Department of Primary Industries

OUT15/14756

Drayton South Coal Project (MP11_0060) Response to exhibition of Environmental Impact Statement

Drayton South Coal Project (MP11_0060) Request for comment on the exhibition of EIS Additional comments / Comment by NSW Office of Water

Figure 4.4 - Drayton South conceptual final landform

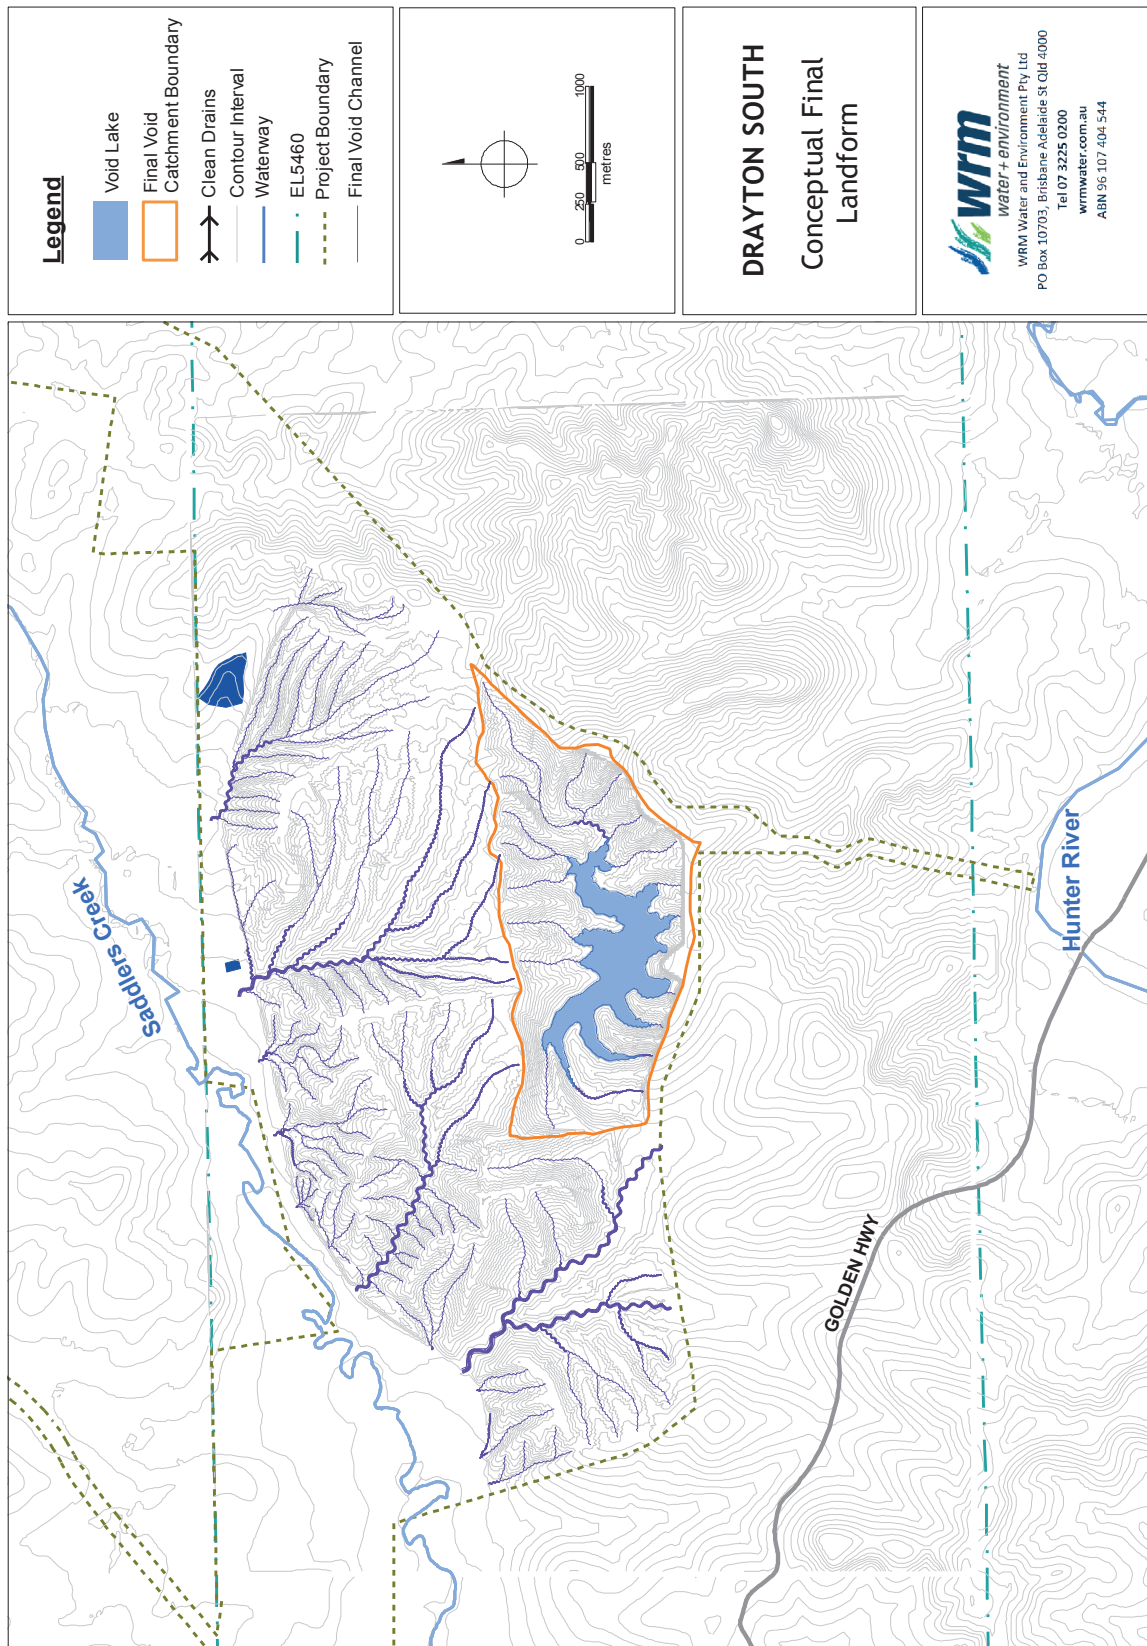
- The proposed reconstructed watercourses are a critical element to the final landform functioning and will require significant assessment and design to ensure long term stability and mitigation of downstream impacts.

- The existing watercourses within the disturbance footprint of Drayton South are to be completely removed during mining and a reconstructed drainage network is to be created on the final landform. Figure 4.4 of Appendix Q indicates the number of tributaries to be created which represents a significant scope of works. The design of the watercourses is to be based on a program called Geofluv. It is expected an extensive understanding of geomorphological and hydrological processes will be required to ensure long term stability and rehabilitation is achieved. Consultation with the NSW Office of Water is requested to ensure consistency with relevant guidelines, policy and legislative requirements.
